## City of Albuquerque Stormwater Construction Site Inspection Report

Project Name:		Champion Xpress					
Location:		4516 Wyoming Blvd					
Site Contact Name & Agency	Jordan - 7Building & Dev.	ESC File No.		F20E005			
	<a href="mailto:jordan@7bdev.com">jordan@7bdev.com</a>	NPDES Id. No.		NMR10028A			
Inspection Date:	02/04/20	Start/End Time:	1120/1125hrs				
CoA Stormwater Inspector:		Timothy E. Sims					
Construction Phase:		foundations					
Type of Inspection:		Regular	Storm Event	Post Storm Event >0.25"	311/Complaint	x Follow Up

C-1.1

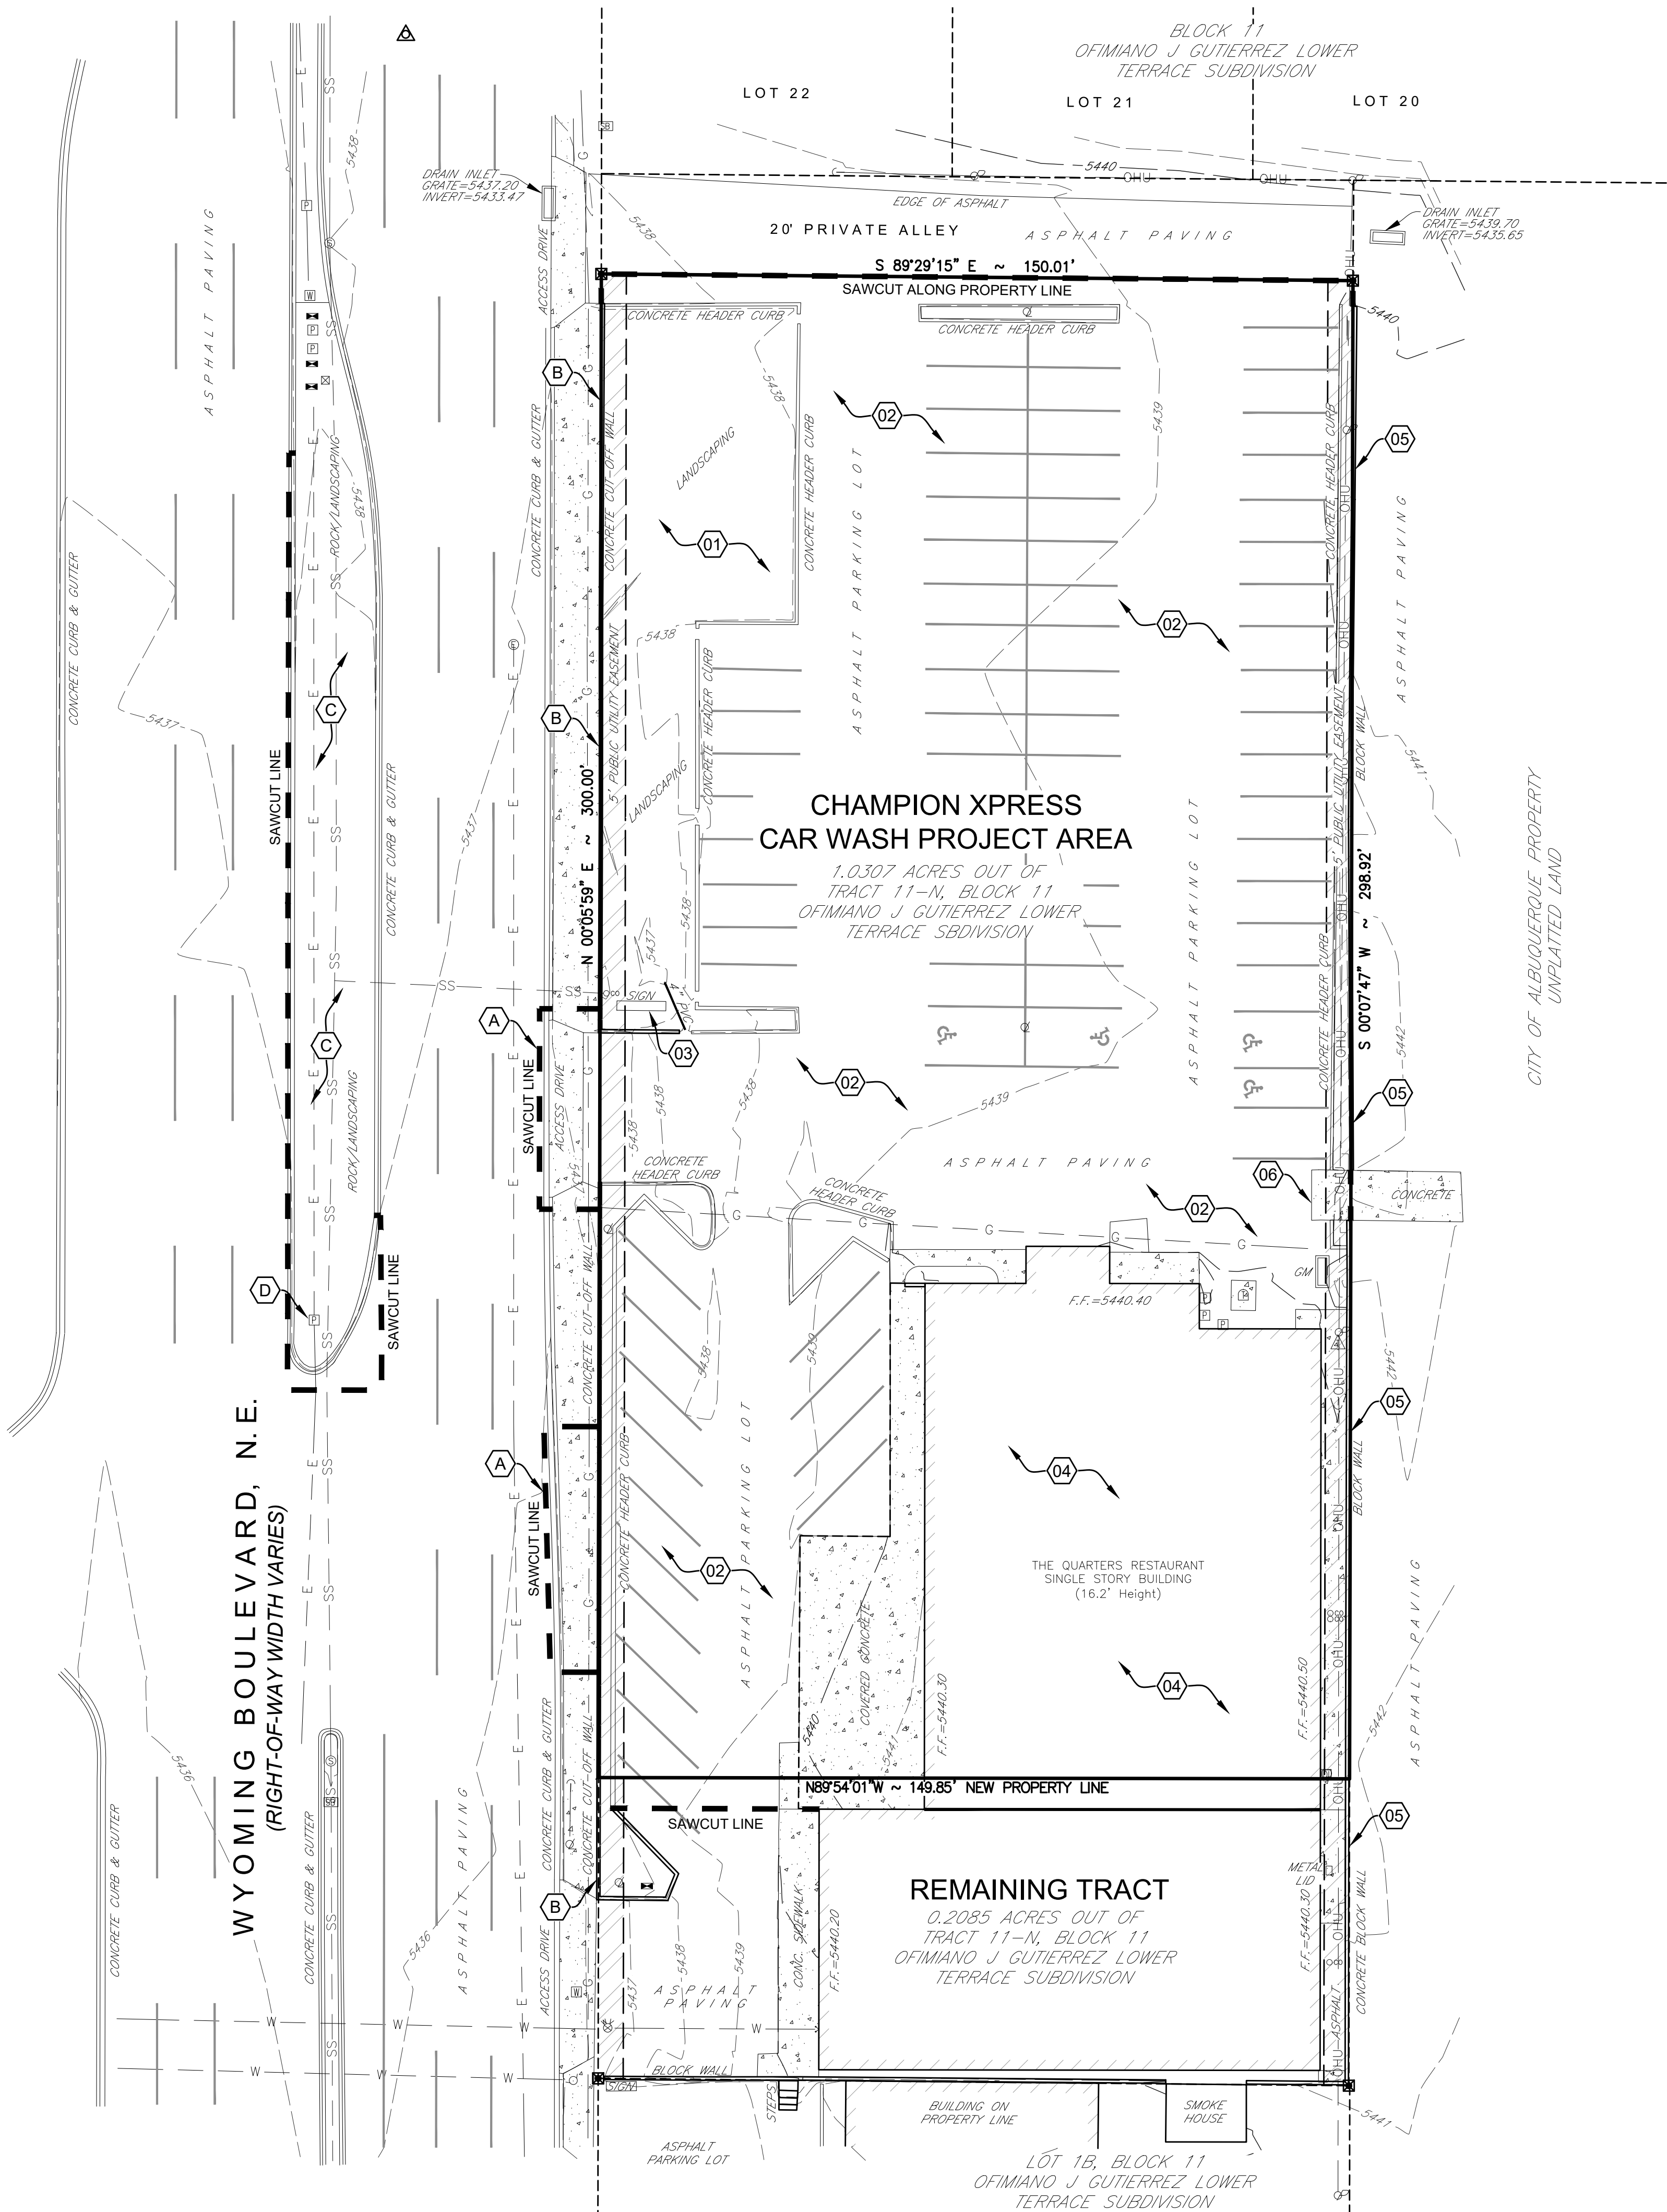
Item Number	Deficiency/ Corrective Action		
1	Please prevent trackout from entering the inlet on the NE corner of the site. This inlet should be protected. Installation of the trackout pad or persistent sediment removal in this area is another option.		
2	Install additional sediment BMP at the existing access points off of Wyoming.		
3	Please provide latest SWPPP self-inspection report.		
2.1	Discharge off site? (Y/N)	No	
4	Self Inspection Reports	requested	Latest report Date: not on file
